From: Ian Gledhill [REDACTED]
Sent: 27 September 2017 11:24
To: David Innes
Subject: WSCC Comments on Cumulative TAs - Pagham

SUBJECT: P/134/16/OUT (Land North of Sefter Road), P/140/16/OUT (South Pagham), and P/6/17/OUT (Land at Hook Lane) – Cumulative Transport Assessments

Figure 13.5 - Proposed mitigation at the B2166 junction with the B2145 (C&A plan ref: 12-018-045)

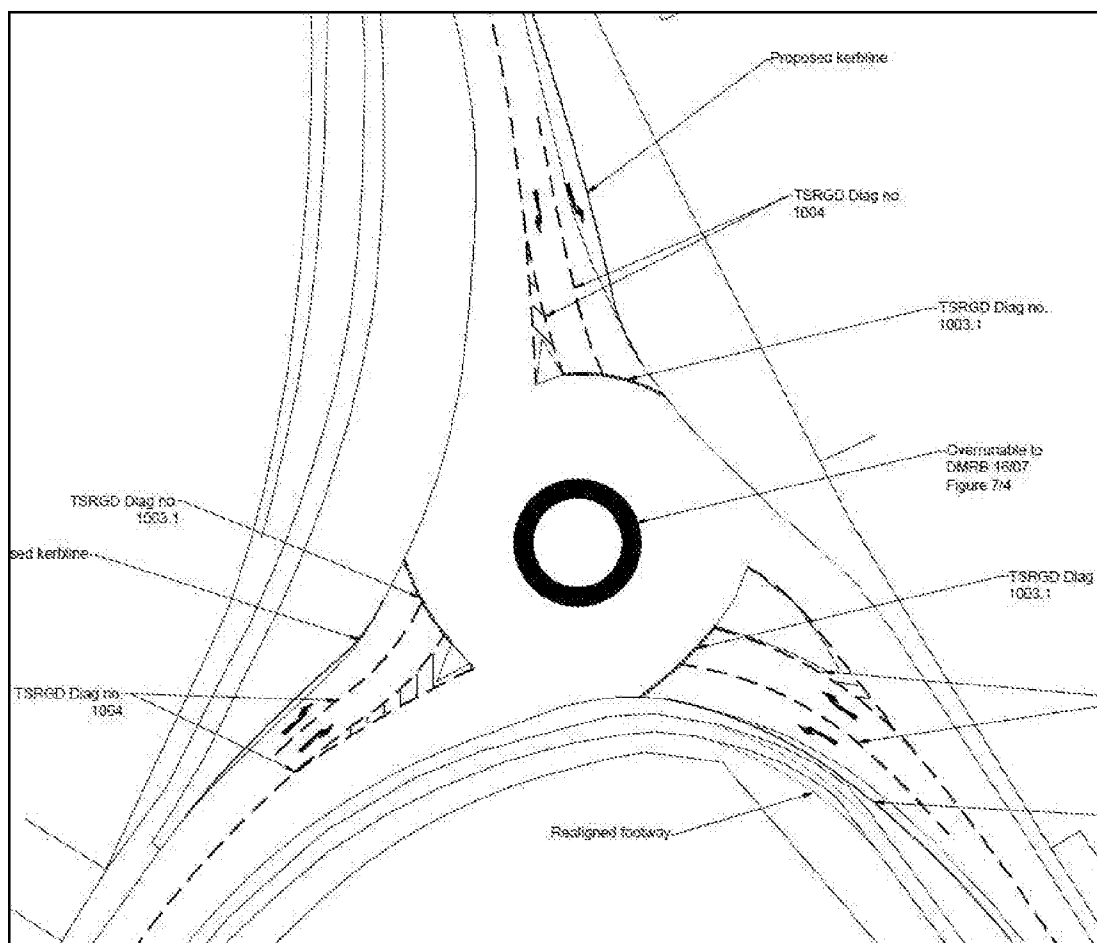
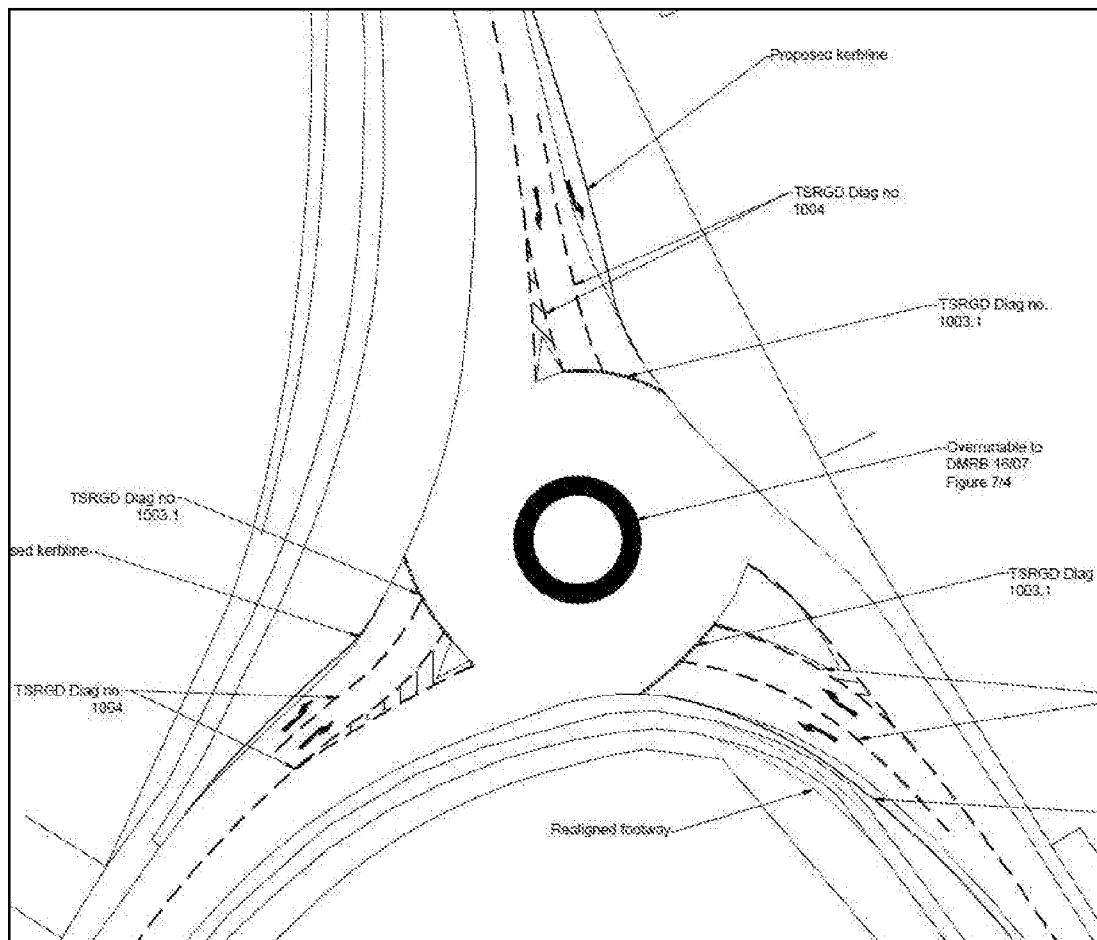
It's apparent that whilst there are differences, there are consistent capacity issues on certain arms in the scenario with the development in both the AM and PM peaks. A scheme of mitigation is consequently proposed. These improvements propose the increase of entry arm widths to varying degrees. The improvement has been the subject of a design check and Stage One Road Safety Audit.

In all scenarios with the proposed improvements, the operation of all arms of improves. It's accepted that the operation on some arms is worse with the additional development than without it. Current national planning policy requires a development only to mitigate the residual severe cumulative impacts. The improvements are considered to resolve the severe residual cumulative impacts arising from the development.
